K/43/21/L & K/42/21/HH

East Kingston House Kingston Lane East Preston, Nr. Littlehampton, BN16 1RS

Retrospective permission for erection of two (number) pellet burner flues on outbuilding

issued for:		PLANNING	
project:	Chris Walters, East Kingston House, Kingston Lane, East Preston, West Sussex BN16 1RS	project number:	CW01
drawing:	Existing Heating Plant & Storage	drawing number:	101
		revision:	-
scale:	1: 100	paper size:	A2
drawn by:	JK	checked:	MD
date:	20.09.21	date:	20.09.21

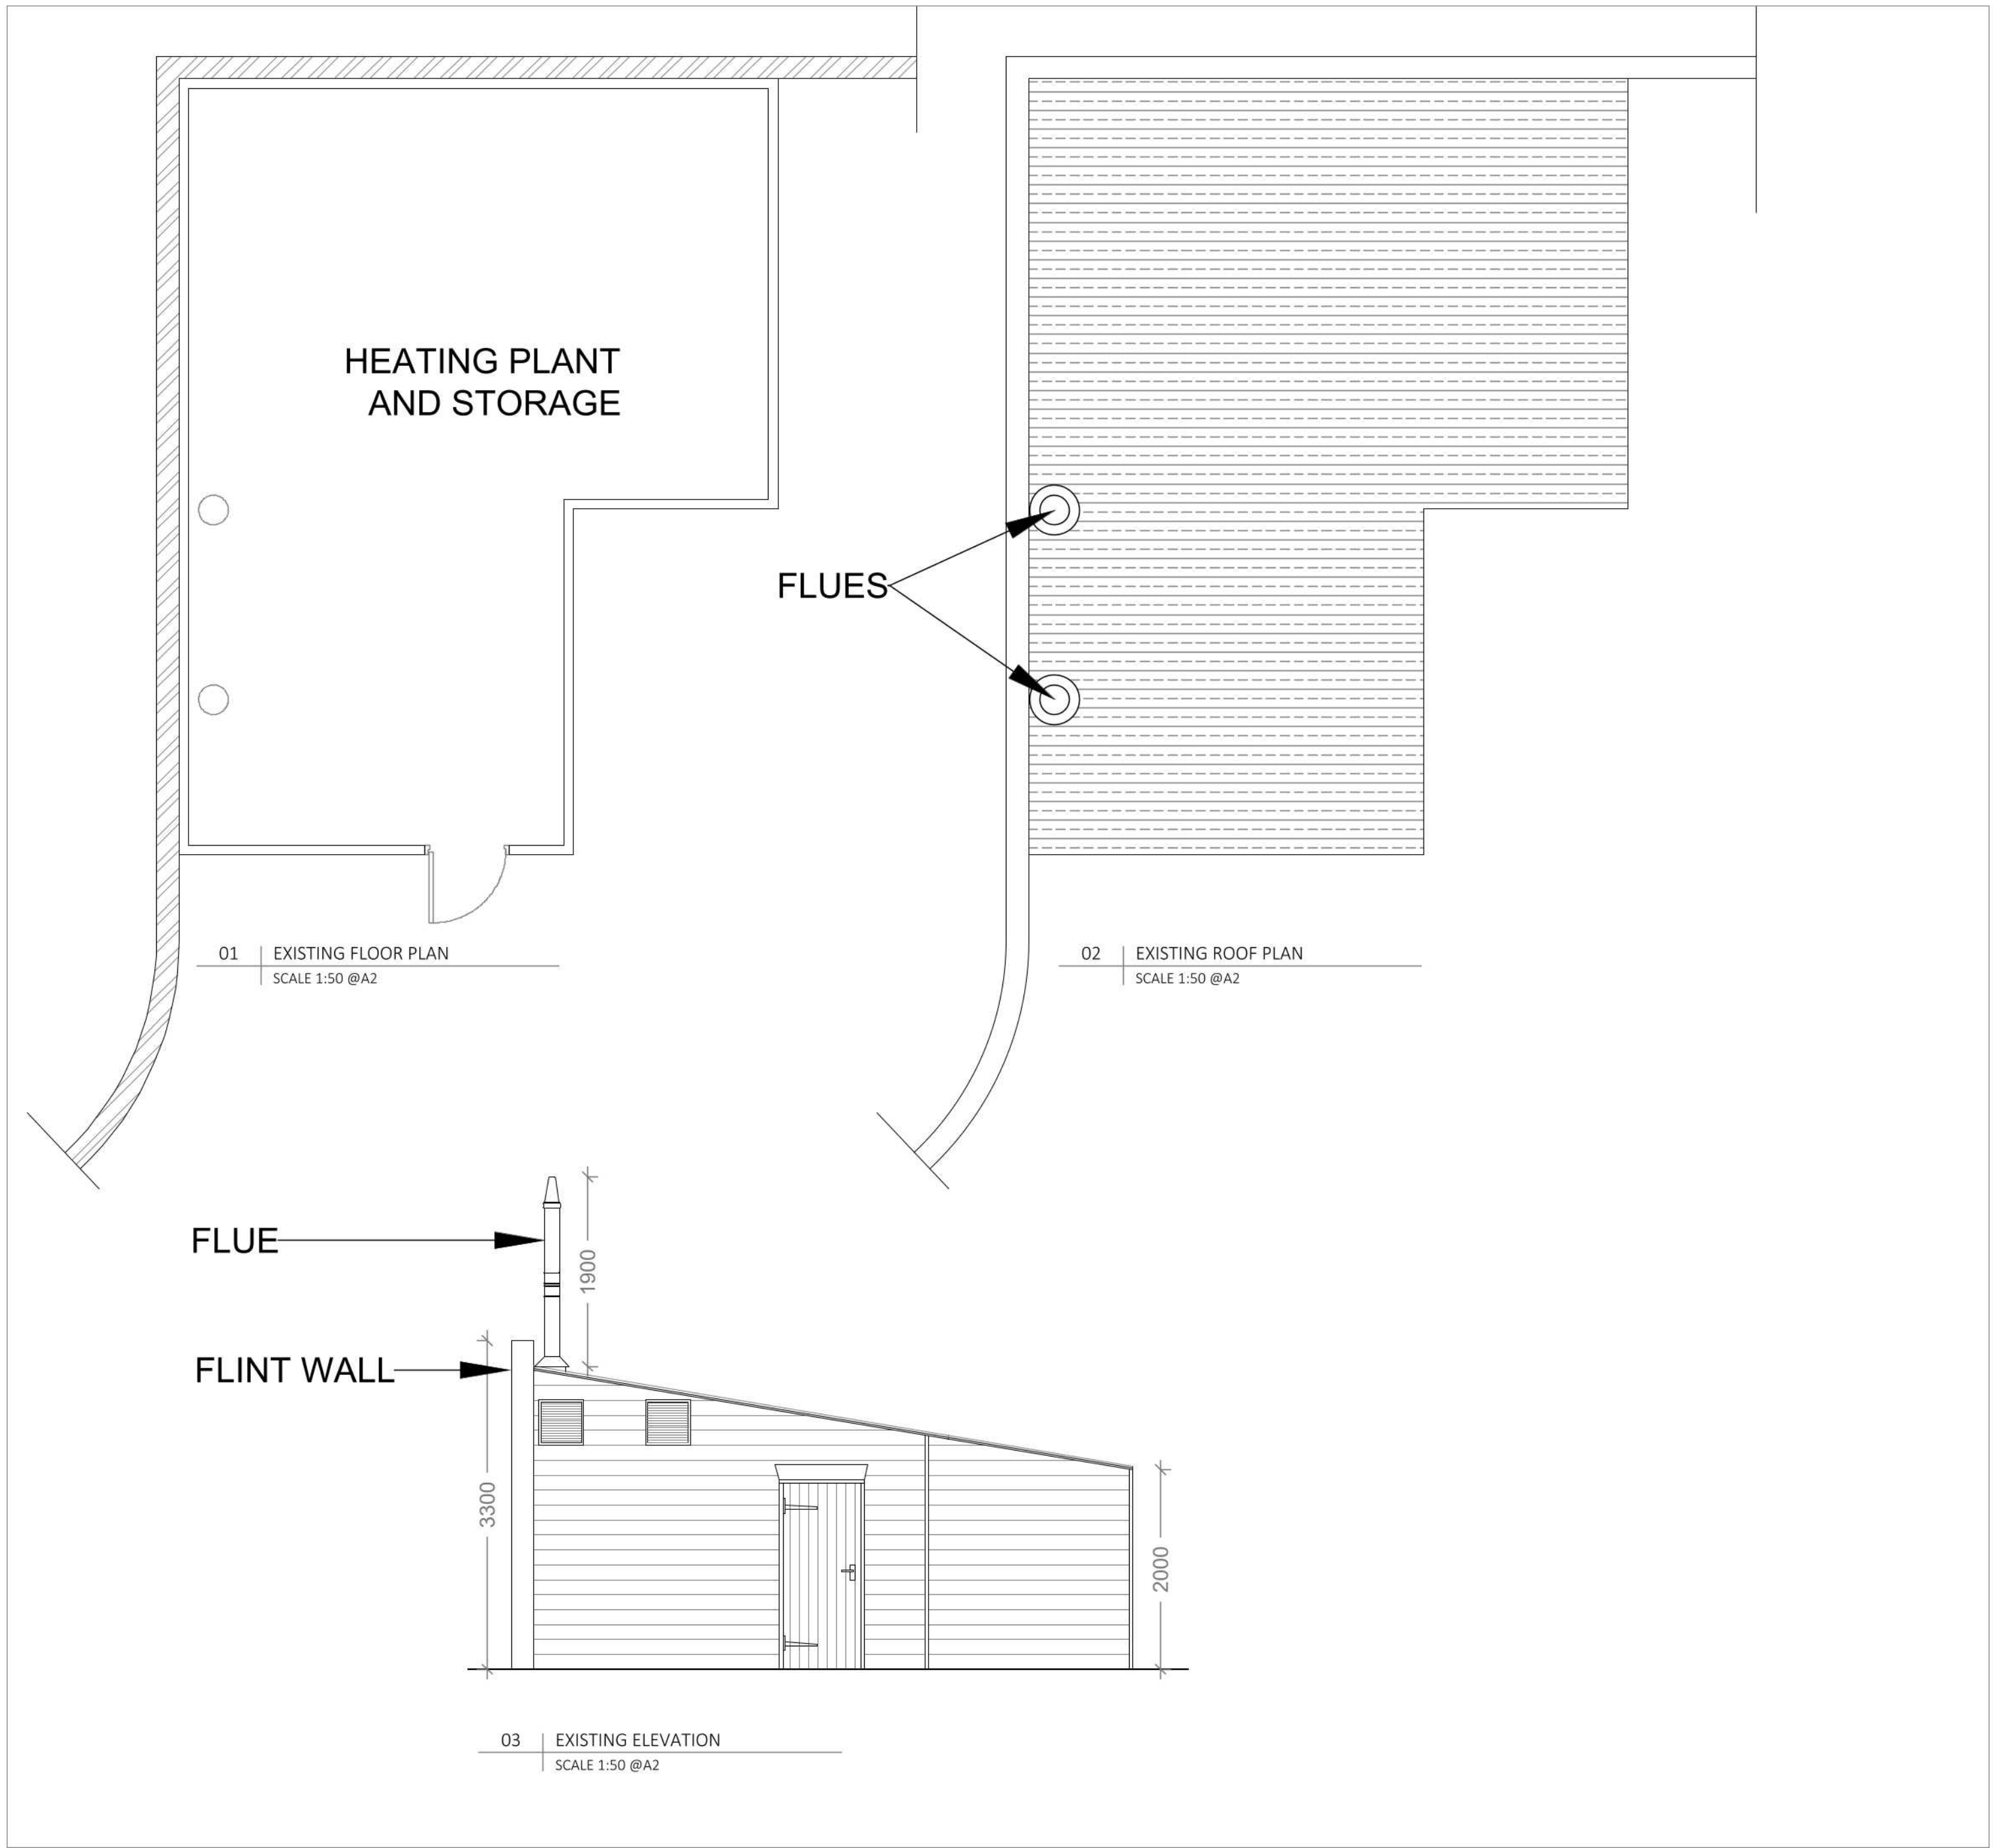
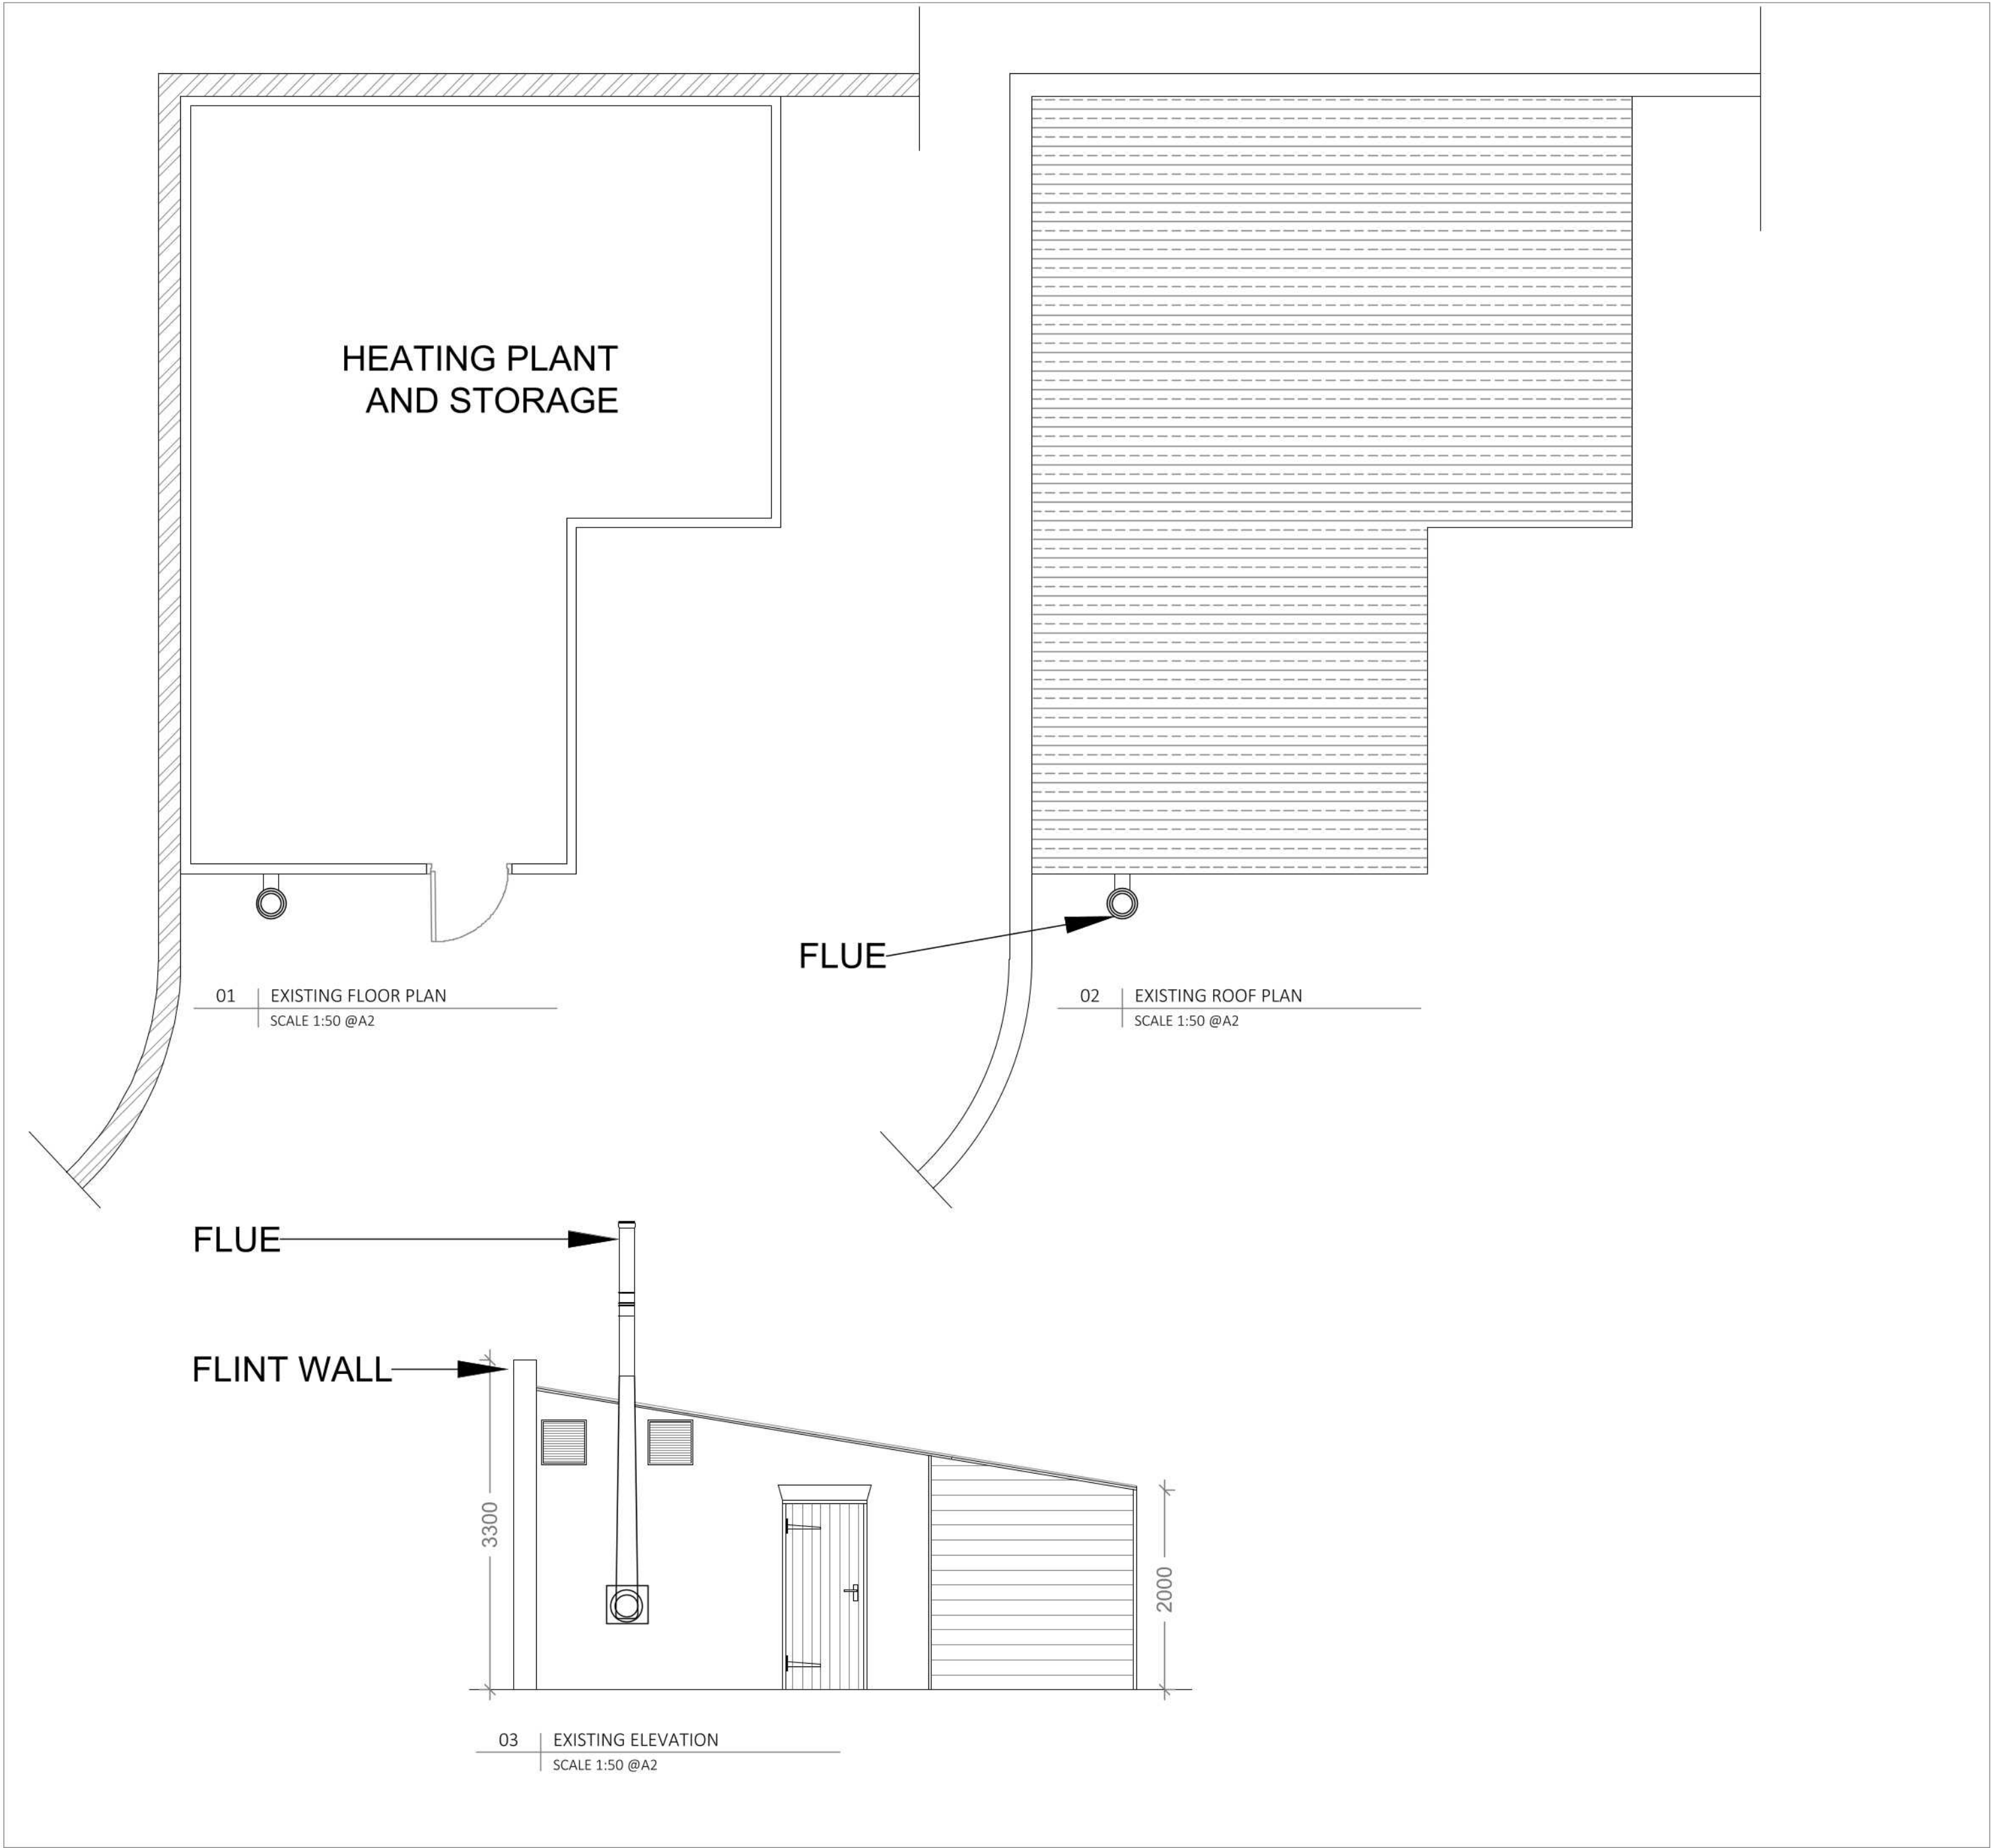
The proposal seeks retrospective permission for erection of two pellet burner flues in an outbuilding. This outbuilding is located to the south-west of the main listed building and is hidden by attractive flint walling. The two flues are located on the roof of the outbuilding and replace one

which was in a similar location. The flues themselves are visible above the roofline of the outbuilding (as the previous one was also) but are of a black colour which helps to reduce their visibility. As with all flues, it is also suggested that they are somewhat temporary elements; like the previous one, they will at some point themselves be replaced. As a result, the view of the front elevation of the building will remain similar to what it was previously. Their impact being lessened from some angles by the presence of existing vegetation, which is positive.

Therefore, on balance, due to the fact that there was a flue in a very similar location, they are a dark colour and partially screened by the trees, I am of the opinion that based on their appearance and location that the flues do not cause harm to the significance of the heritage asset or its setting. As a consequence, it should be determined in accordance with the relevant policies within the Development Plan, along with these comments. You will also need to take into account the contents of the Planning (Listed Buildings and Conservation Areas) Act 1990 (as amended).
